**ADC Planning Consultation  
Response from the Historic Buildings Adviser**

| <b>Application Number</b> | AB/7/14/                                                                                                                                      |
| <b>Address</b>            | 33 Maltravers Street Arundel BN18 9BU                                                                                                         |
| <b>Description</b>        | Ground floor rear extension and internal alterations. This application may affects the character and appearance of Arundel Conservation Area. |

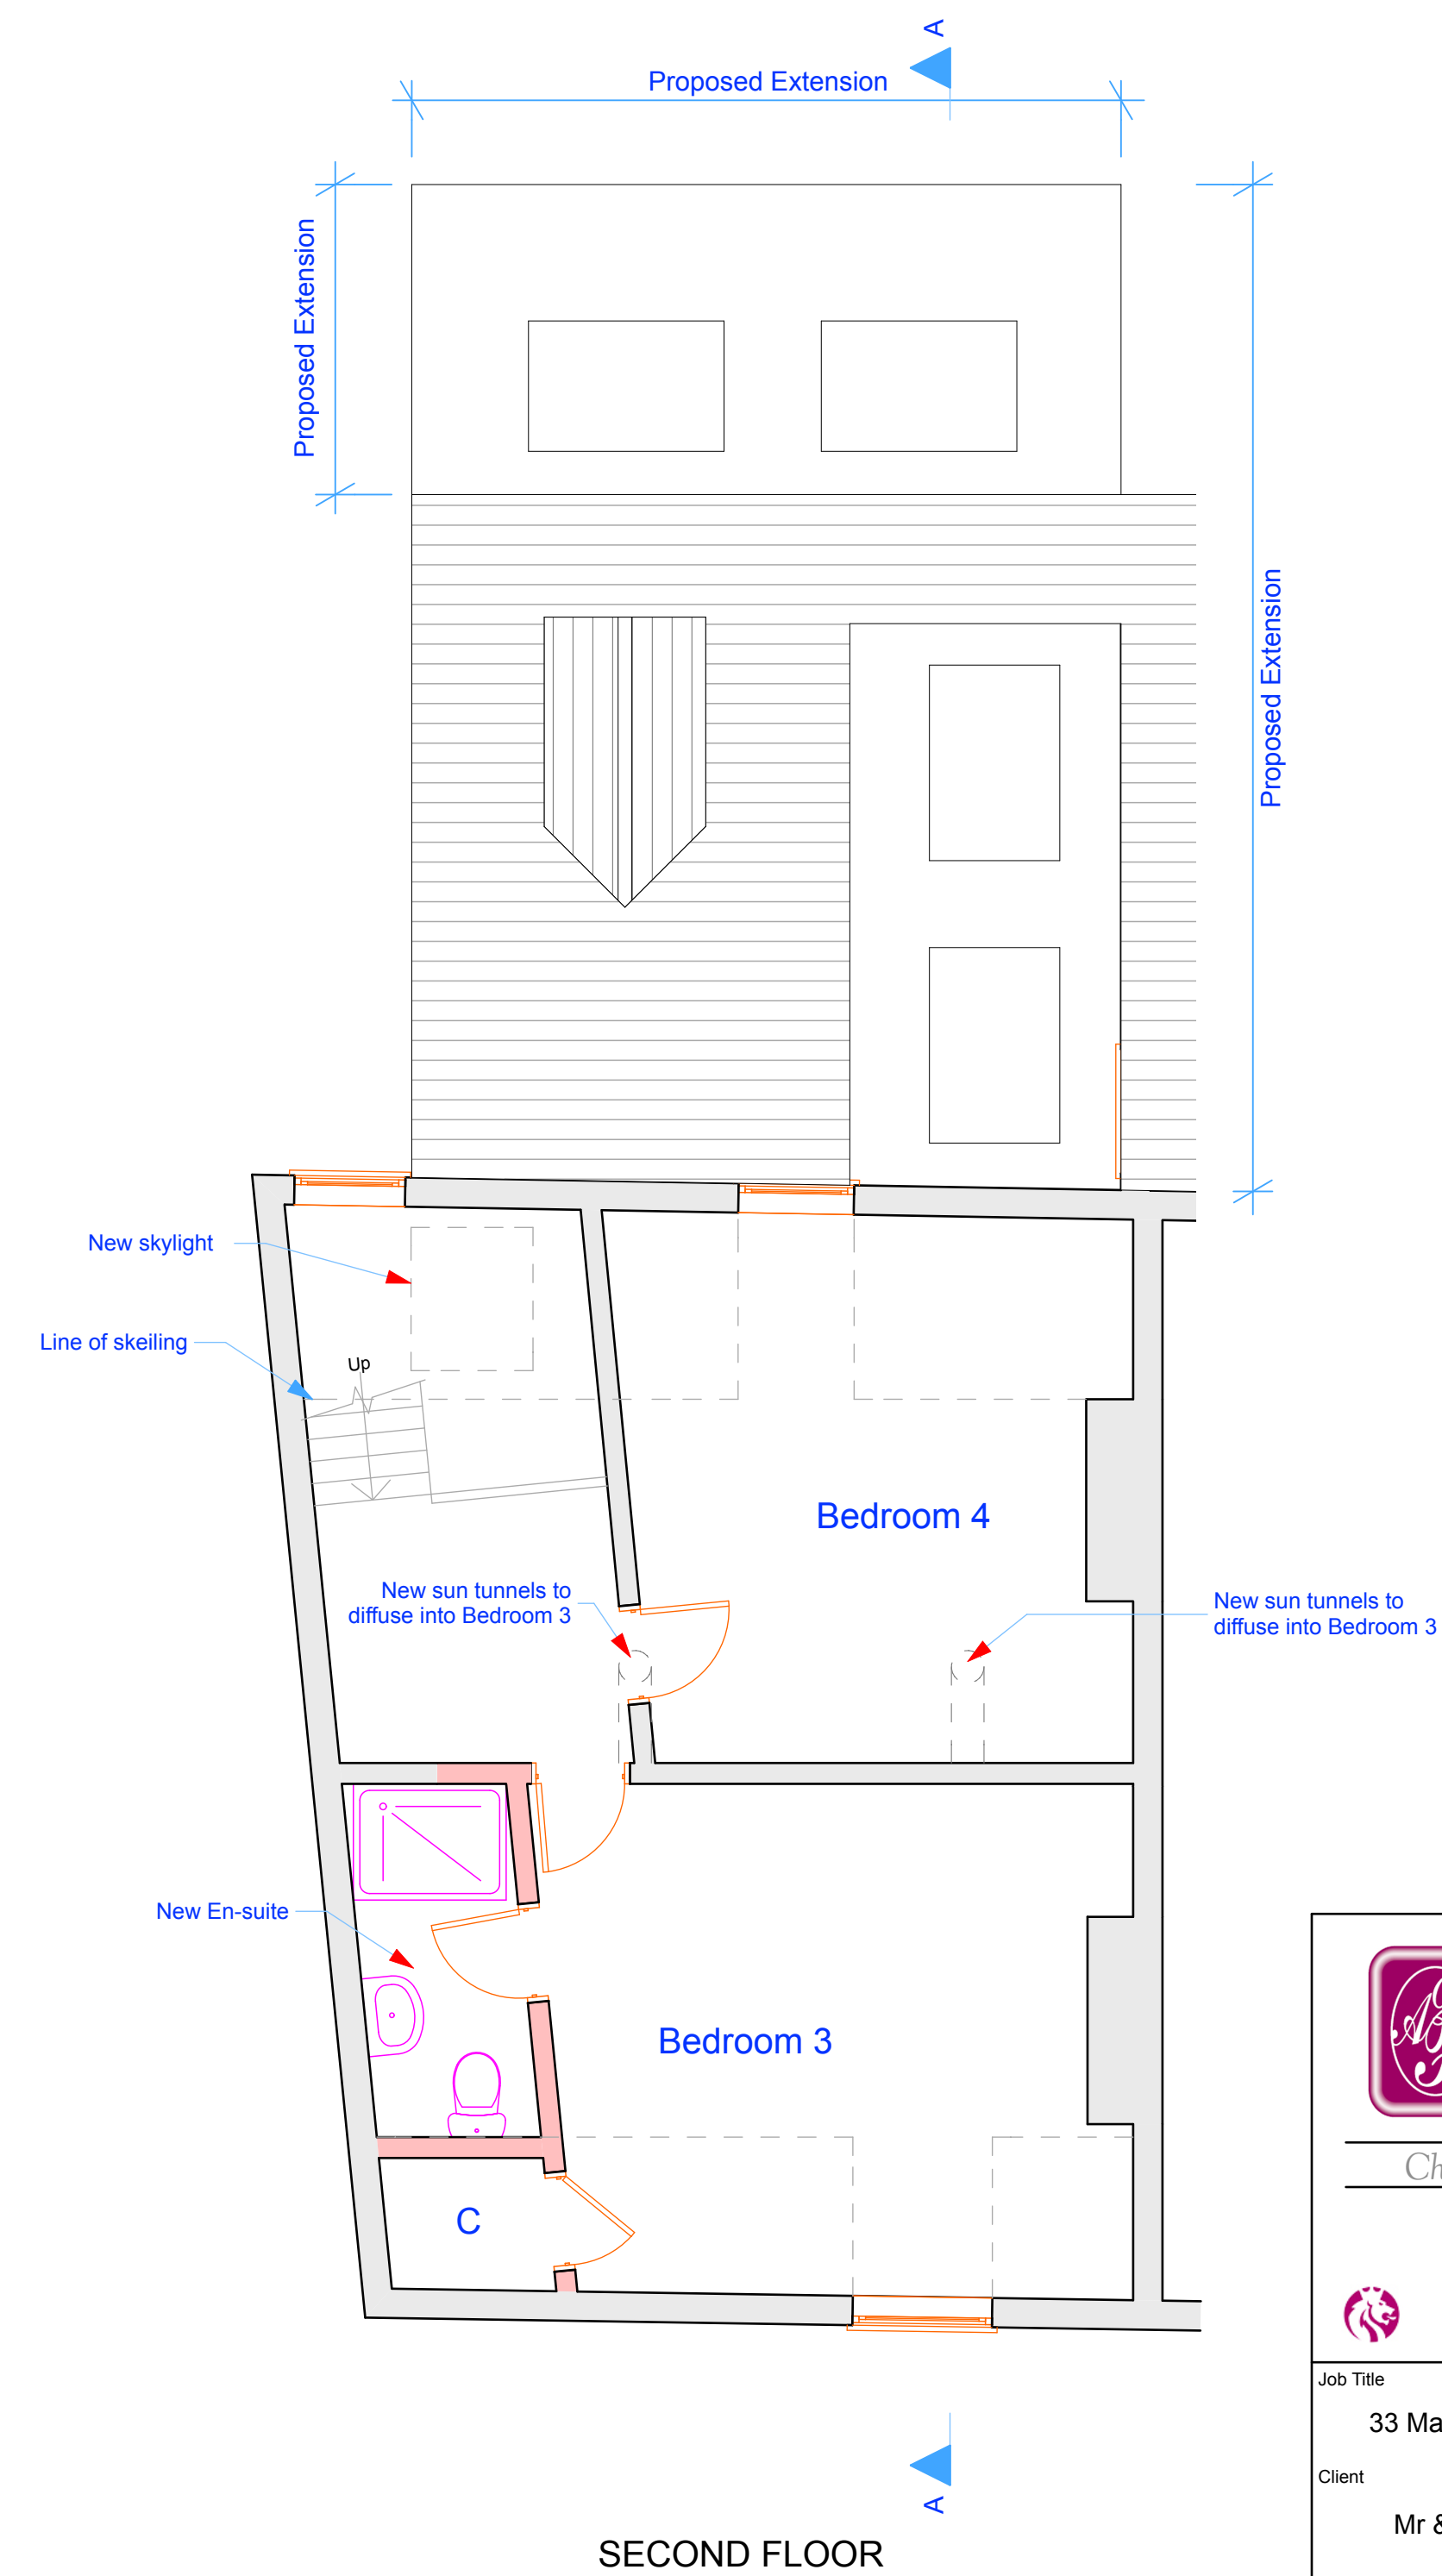
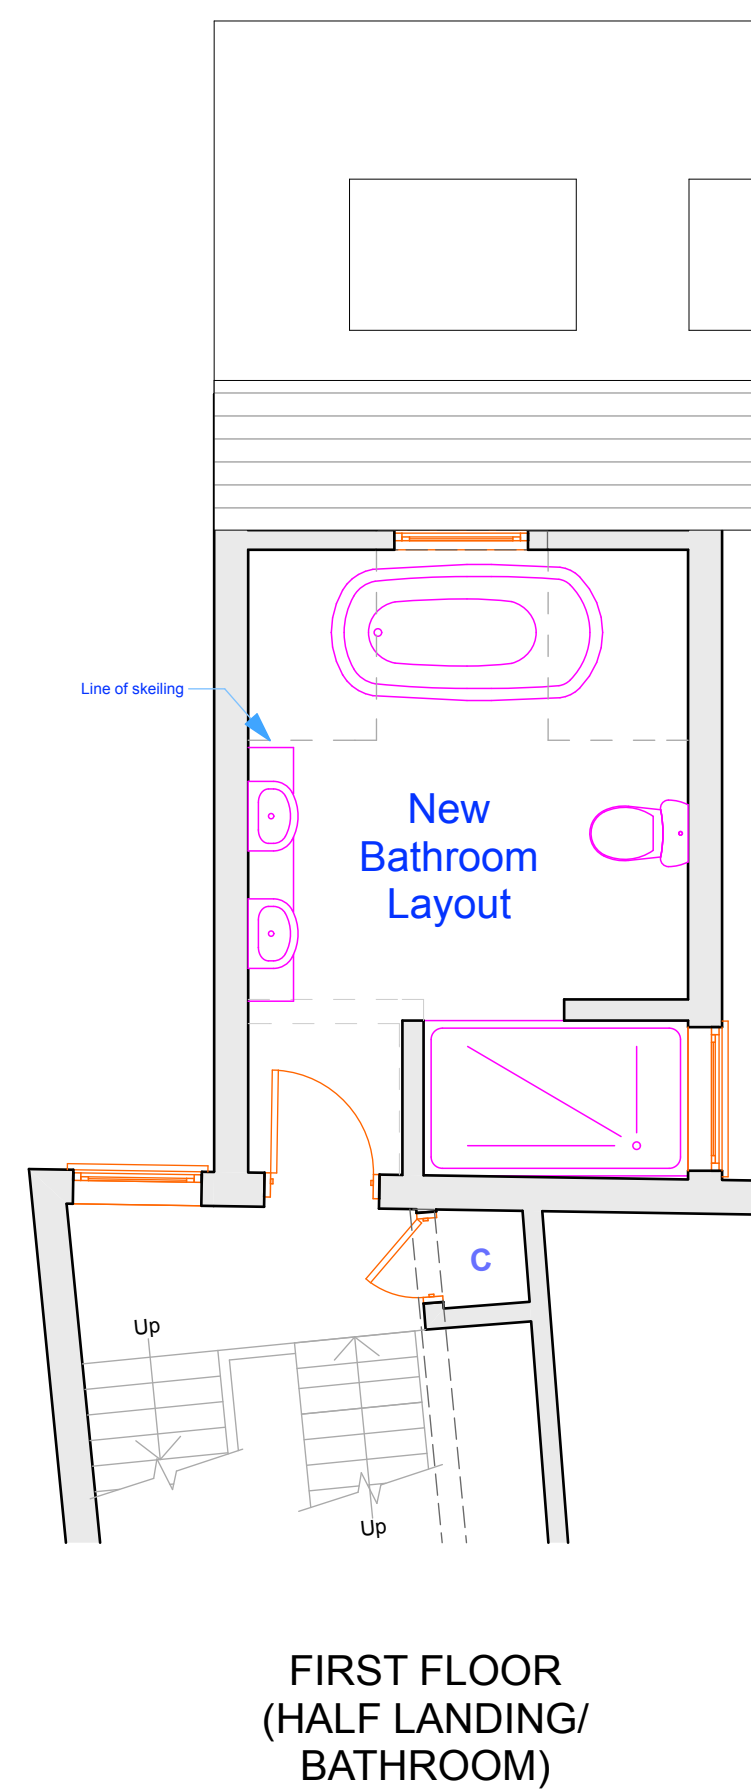
This scheme is generally acceptable on the basis that the addition is relatively subservient. The retention of the wall nibs to express the earlier structure as discussed is also welcome.

SOUTHEAST ELEVATION

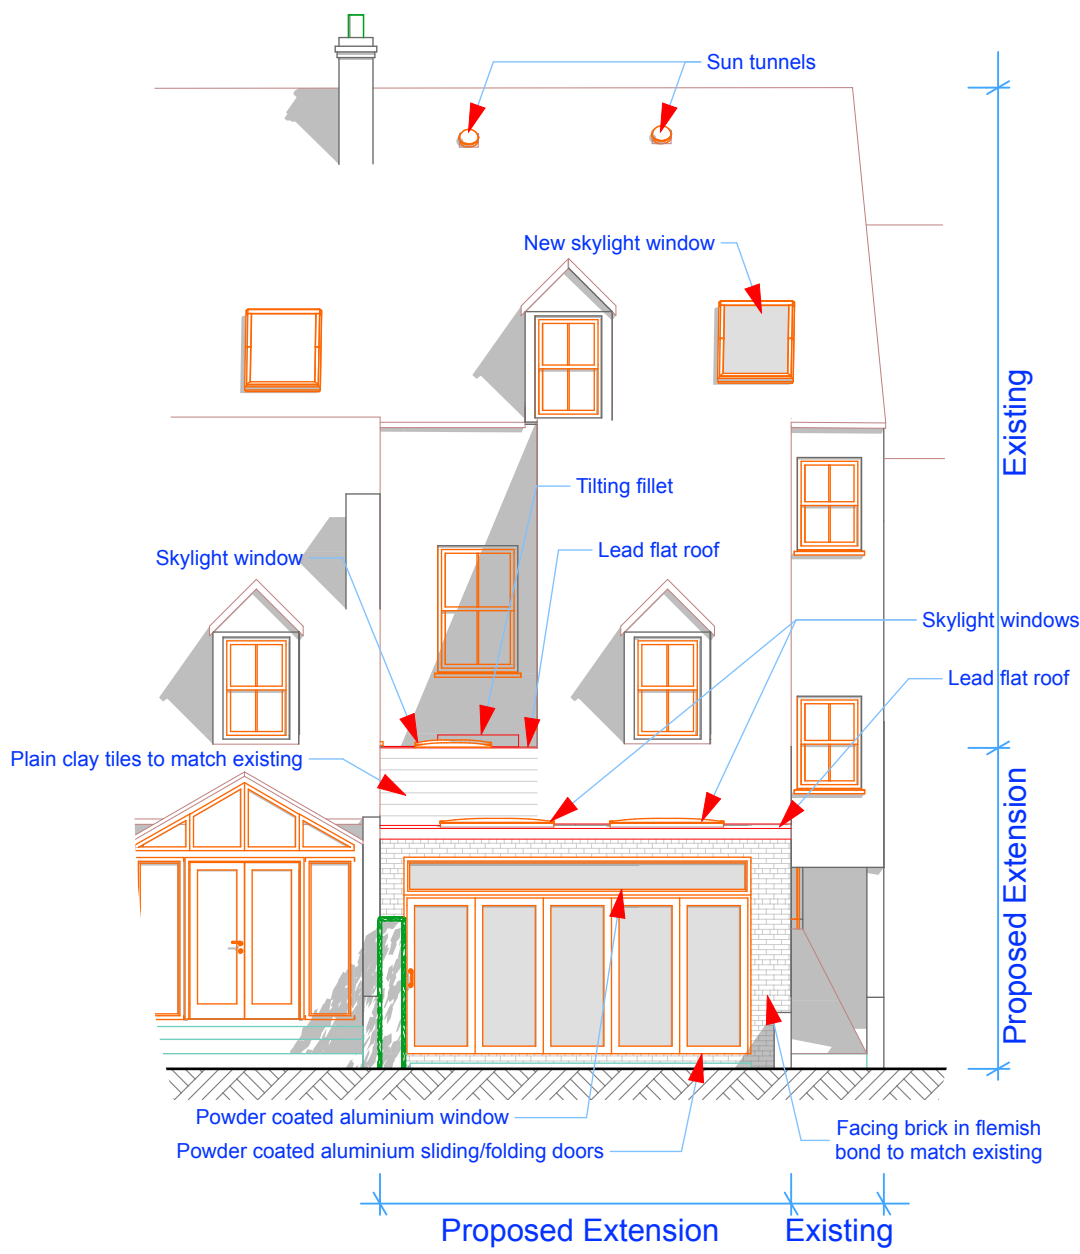
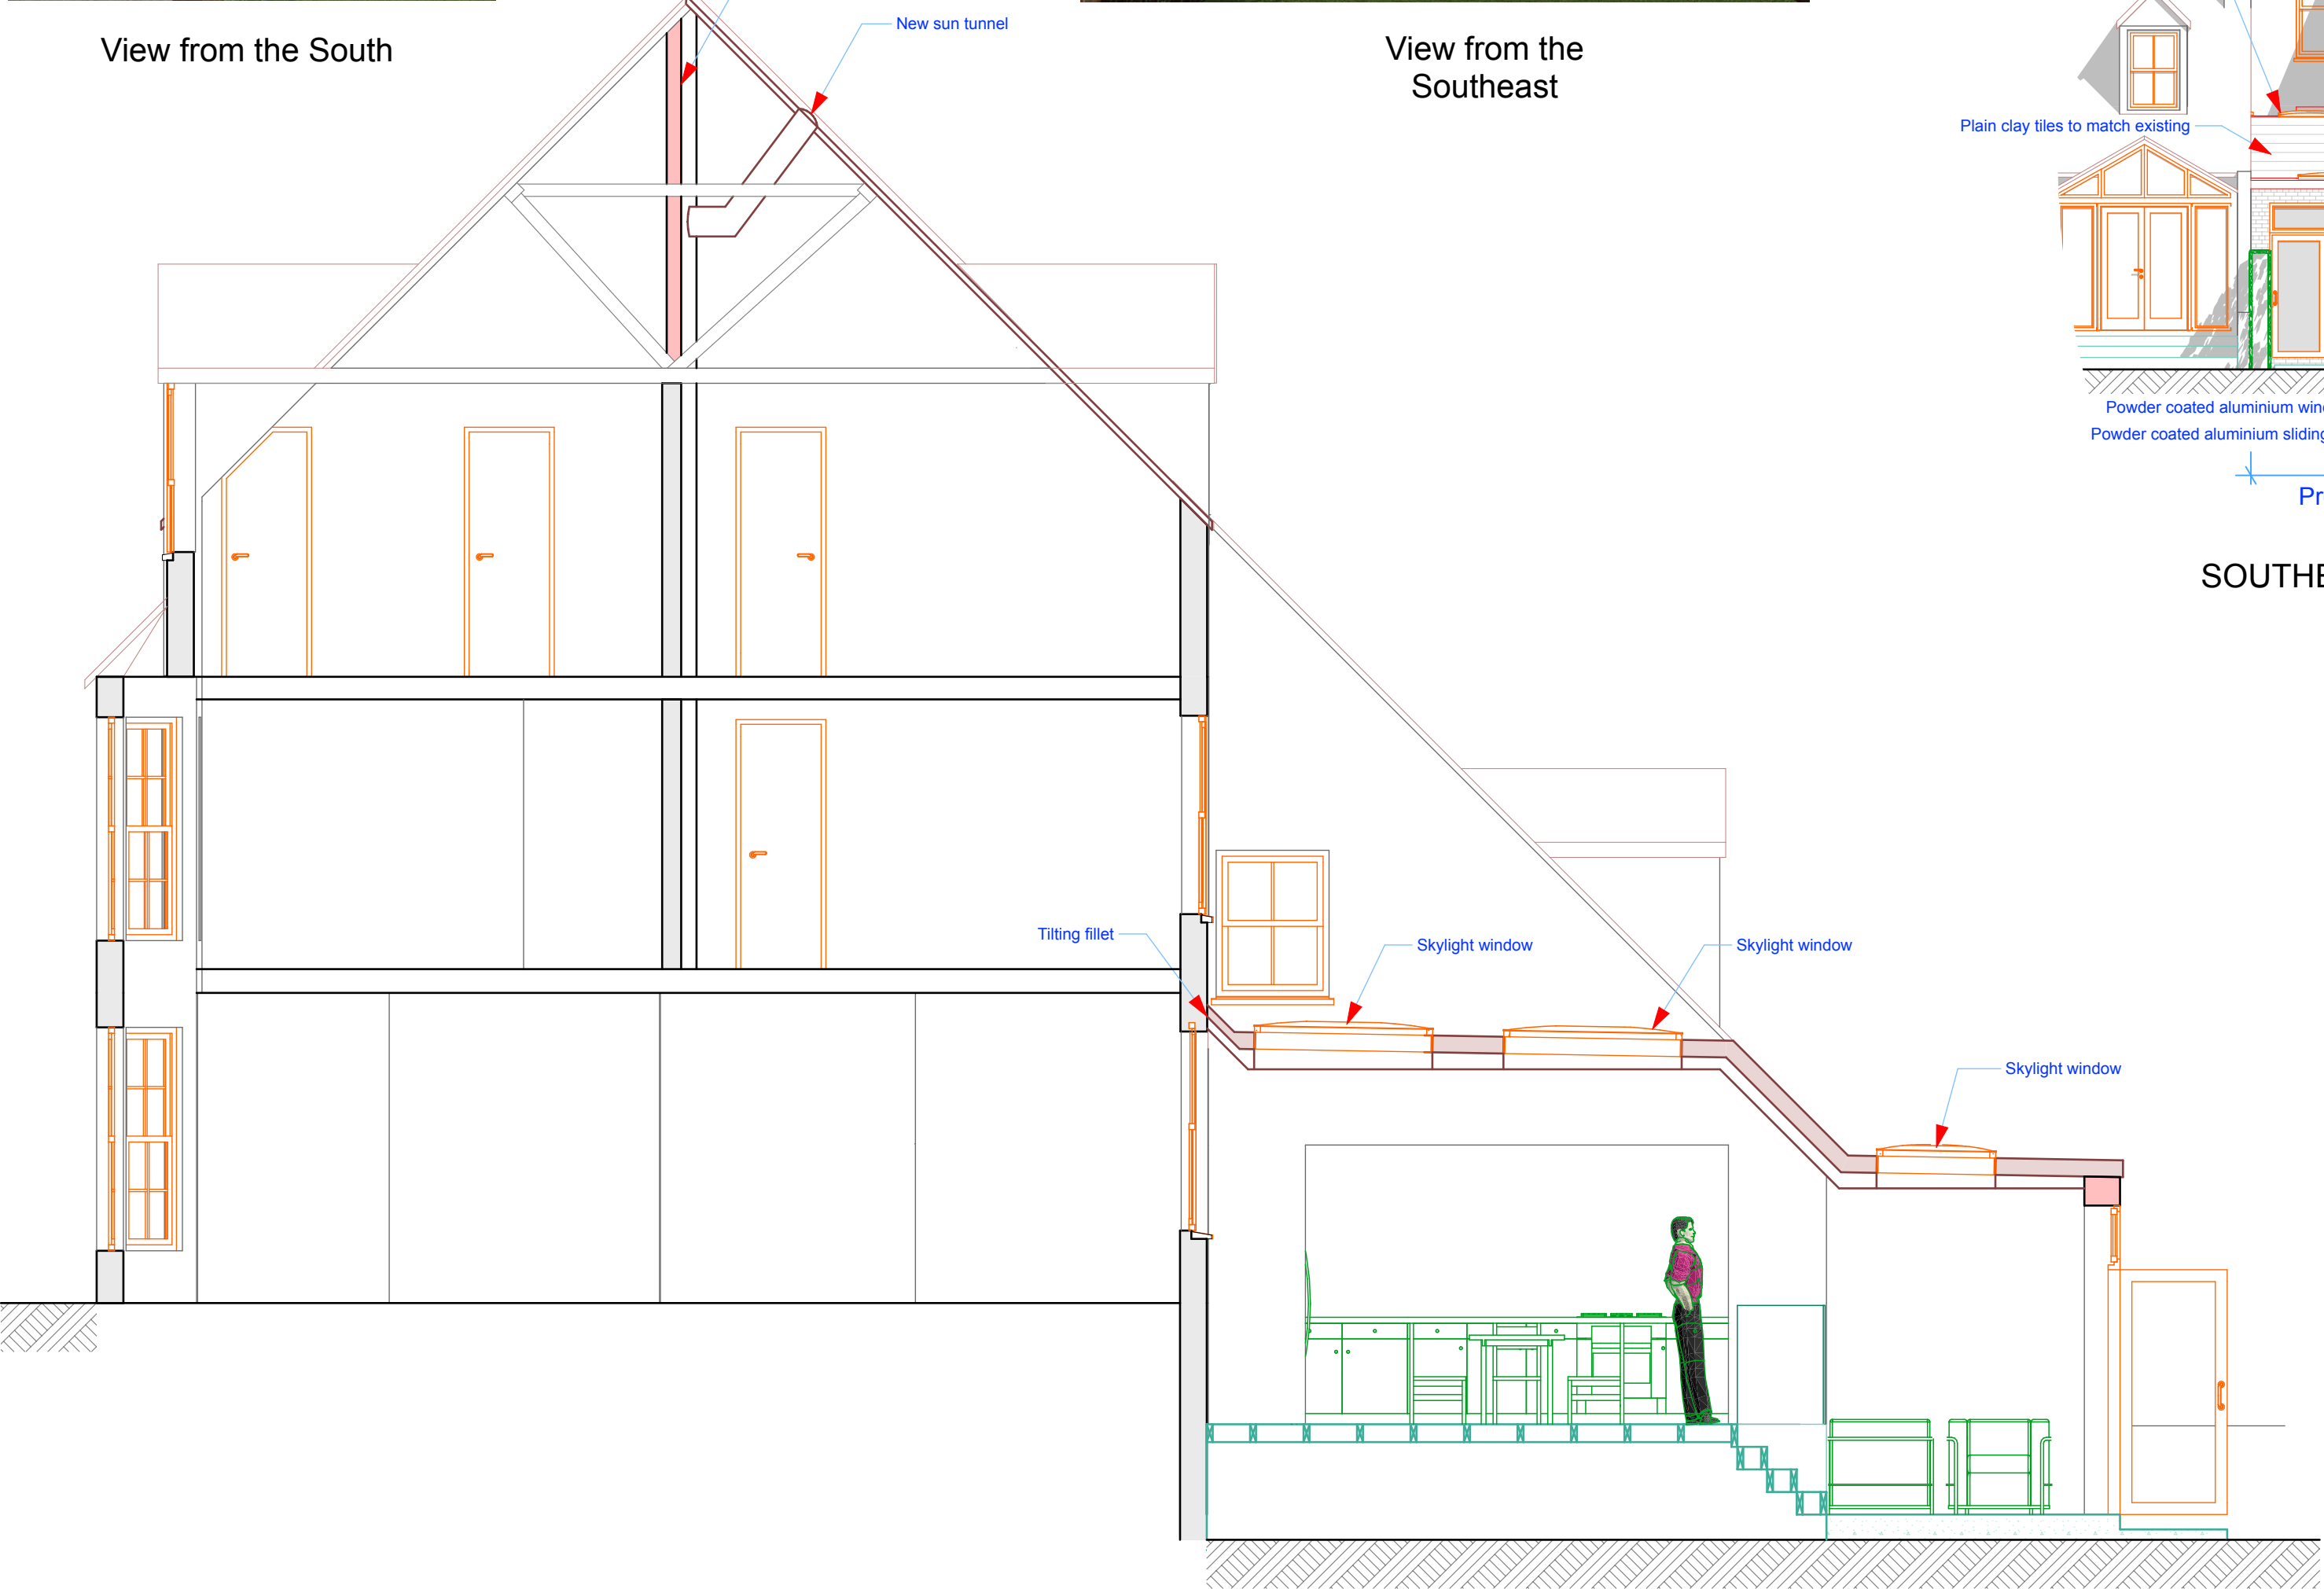
Our only concern is the large horizontal window above the folding doors. This should ideally be subdivided to match the door widths. This will make it more sympathetic with the new and existing fenestration.
